From: Sarah Burrow <Sarah.Burrow@arun.gov.uk>
Sent: 11 January 2021 17:58
To: Planning.Responses <Planning.Responses@arun.gov.uk>
Cc: Andrew Wood <Andrew.Wood@arun.gov.uk>
Subject: RE: Planning Consultation on: R/227/20/PL

Engineers Comments Regarding Surface Water Drainage

Application No: R/227/20/PL
Registered: 26th November 2020
Site Address: Laundry 38 Oakhurst Gardens Rustington Littlehampton BN16 3AN
Grid Reference: 506182 102651
Description of Works: Demolition of existing laundry building, lean to & shed, construction of a ground & first storey accommodation building housing 3 No. sheltered housing flats & construction of a single storey laundry building including upgrade of associated clothes drying area & surrounding landscaping. This site is in CIL Zone 5 (Zero Rated) as sheltered housing.

Project	Laundry & Accommodation Oakhurst Gardens	Project No.	010
Client	Littlehampton & Rustington Housing Society	Date	Drawn ES
Scale / Format	1:250 @ A1 1:500 @ A3	Checked JT	Issue P1
CAD Reference	Approved SM	Drawing No.	010-X-10-02
Drawing Name	Proposed - Block Plan

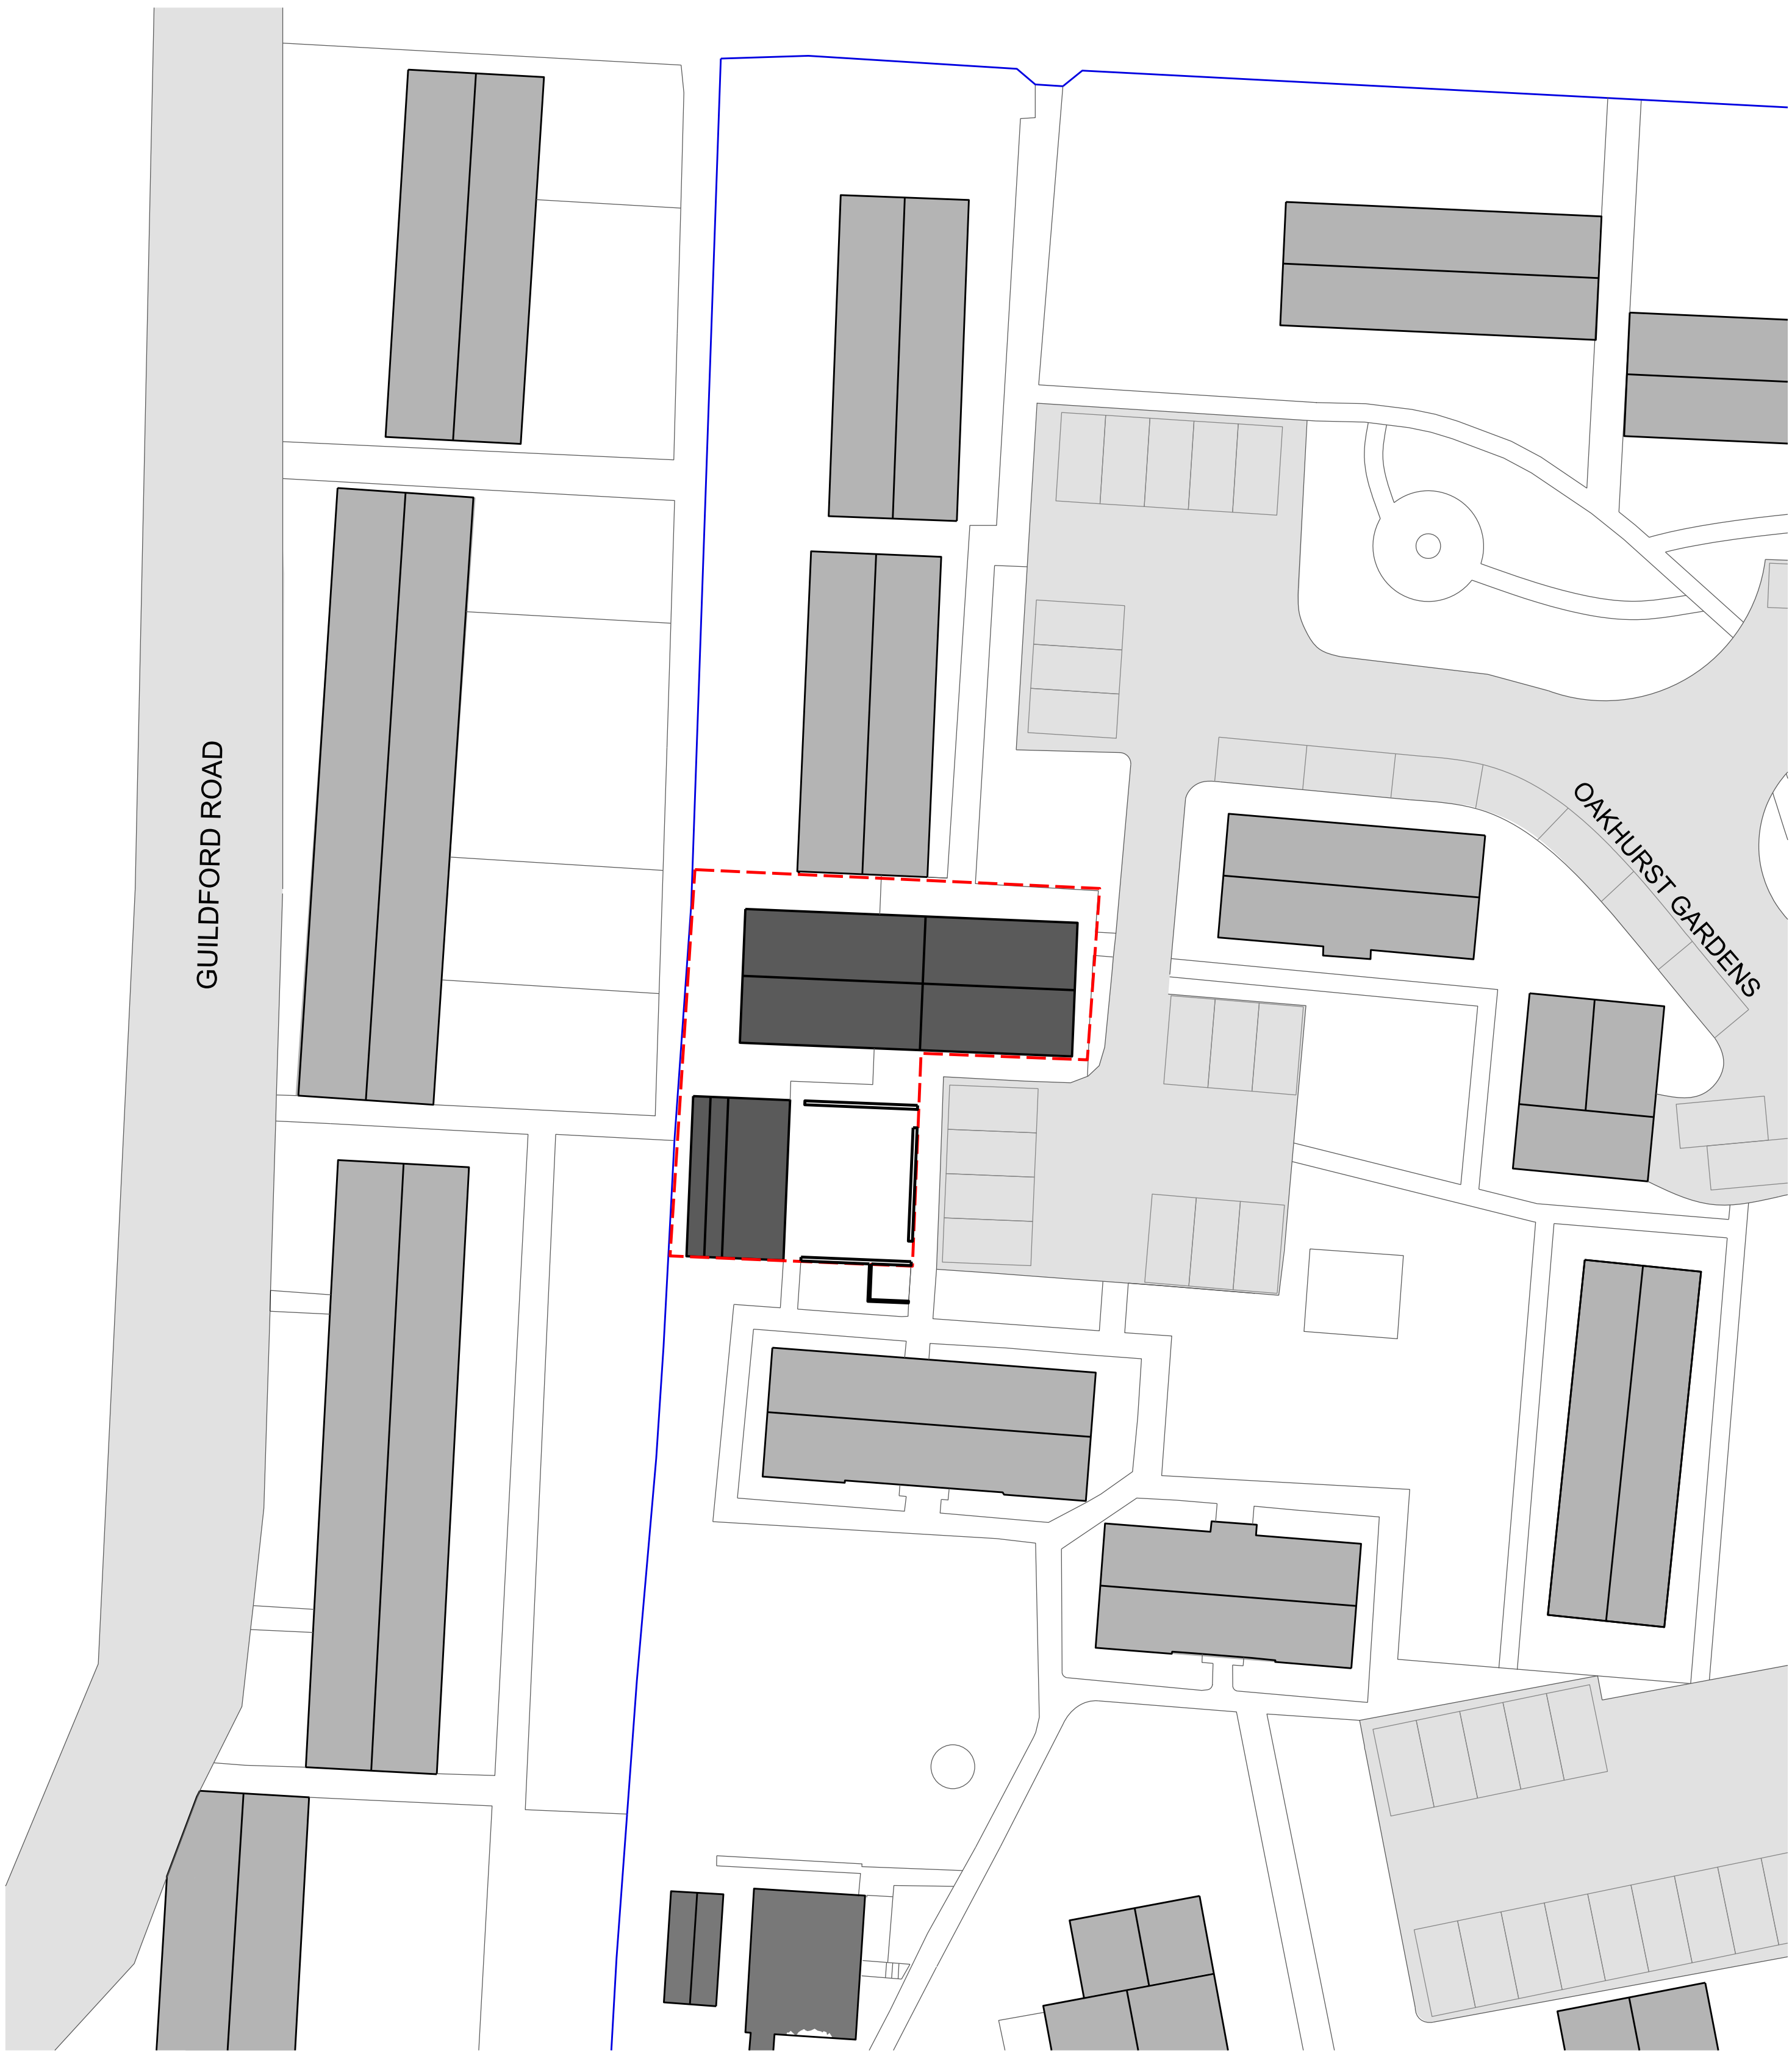
If infiltration is viable on the site then lack of space is not an adequate excuse for not utilising soakaways/infiltration structures. Soakaways must be located a minimum of 5m from any buildings, and 2.5m from the site boundaries. Given these constraints, I do not see how surface water from the site can be sustainably drained within the red line boundary of the site.

Therefore, I wish to lodge a holding objection to the application.

It is understood that there is a larger ownership within the blue line boundary and it is accepted that if the red line boundary was to be redrawn to include the car park to the east of the proposed buildings then there should be adequate space for surface water drainage in this area. In this instance I would be happy to withdraw the objection and instead recommend the application of standard condition PCENG2 (should you be minded to approve the application).

PCENG2

“Development shall not commence, other than works of site survey and investigation, until full details of the proposed surface water drainage scheme have been submitted to and approved in writing by the Local Planning

Authority. The design should follow the hierarchy of preference for different types of surface water drainage disposal systems as set out in Approved Document H of the Building Regulations, and the recommendations of the SuDS Manual produced by CIRIA. Winter groundwater monitoring to establish highest annual ground water levels and winter Percolation testing to BRE 365, or similar approved, will be required to support the design of any Infiltration drainage. No building / No part of the extended building shall be occupied until the complete surface water drainage system serving the property has been implemented in accordance with the agreed details and the details so agreed shall be maintained in good working order in perpetuity."
